June 5, 1996

RE: ENGINEER CERTIFICATION FOR EWING PLASTICS (C17-D14D)
ENGINEER'S CERTIFICATION STATEMENT DATED 5/10/96.

RE: REVISED DRAINAGE PLAN FOR EWING PLASTICS (C17-D14D)
REVISION DATED 1/8/96.

RE: DRAINAGE PLAN FOR EWING PLASTICS (C17-D14D) ENGINEER'S
STAMP DATED 12/4/95.

GRADING & DRAINAGE PLAN

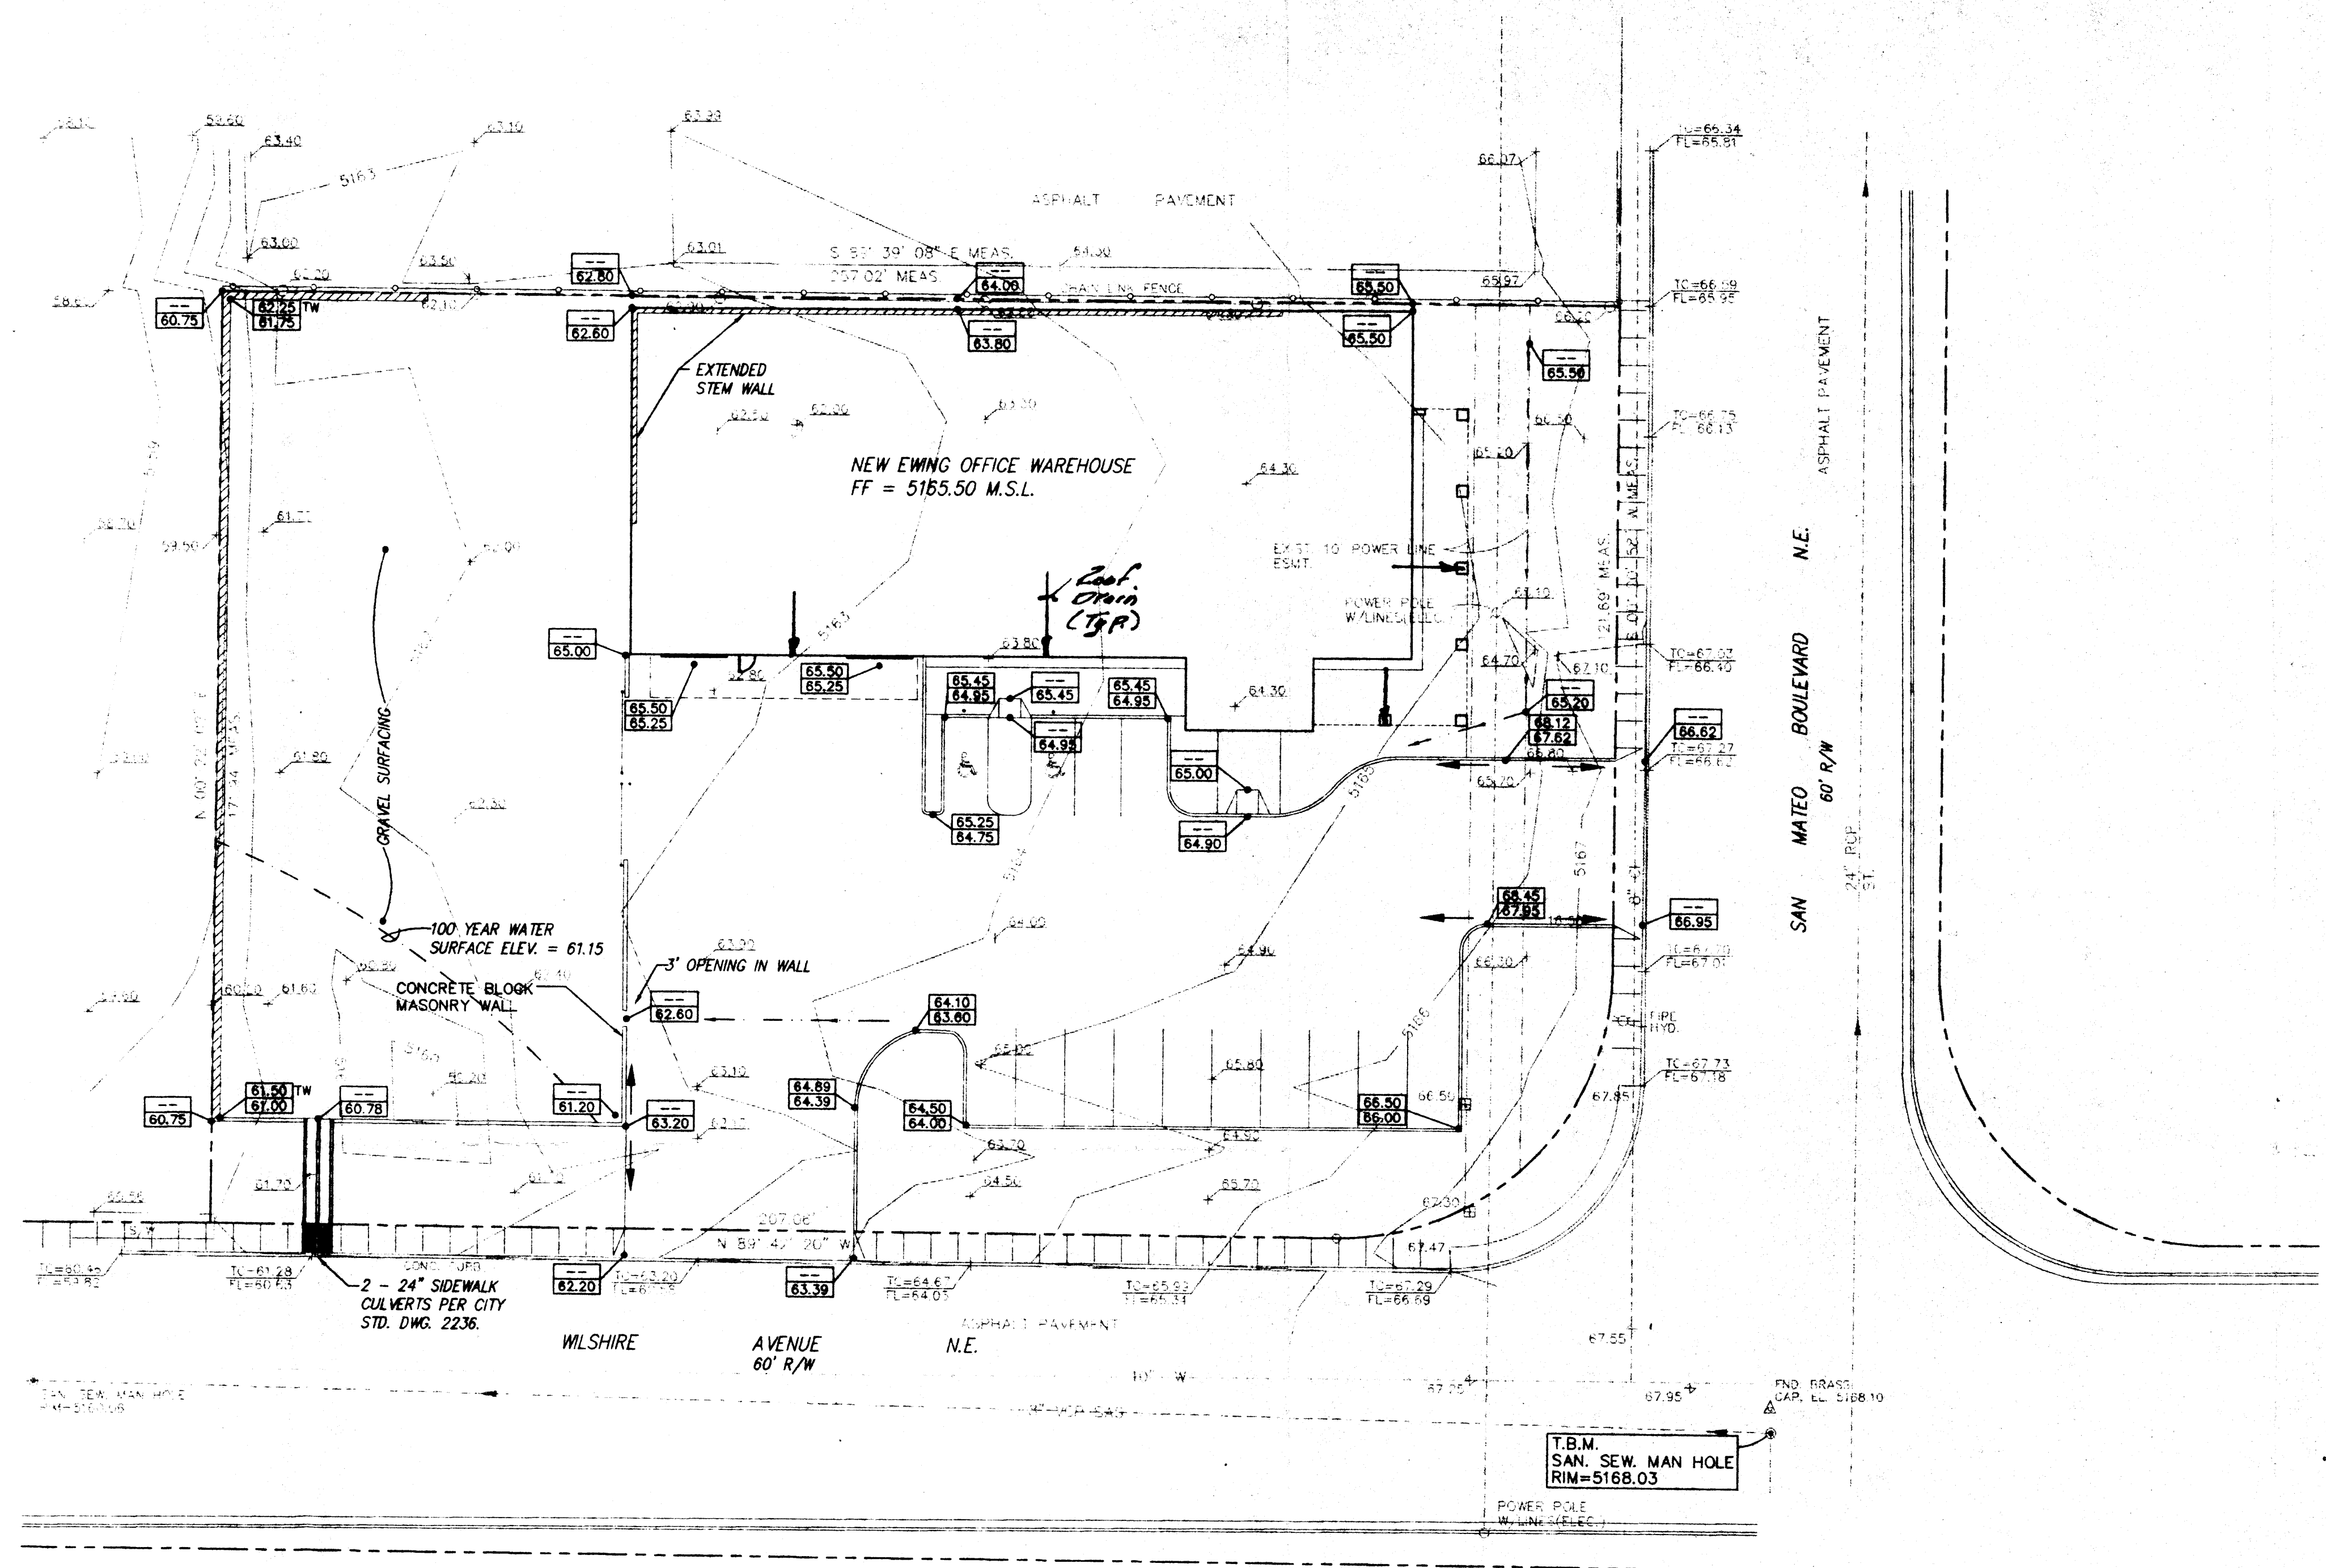
1. Direction & location of roof drains.
2. Please show your full calculations for determining the sidewalk culvert capacity using the Weir equation.
3. What type of sediment control do you propose within the binding area prior to out letting through the culverts?

- 1. Roof drains are now shown.*
- 2. Sample weir calculation is attached.*
- 3. Sediment control will be within the graveled parking / ponding area. The gravel will help reduce the oils, and the slope of 0.7% shall reduce the velocity such that sediment deposition should occur.*
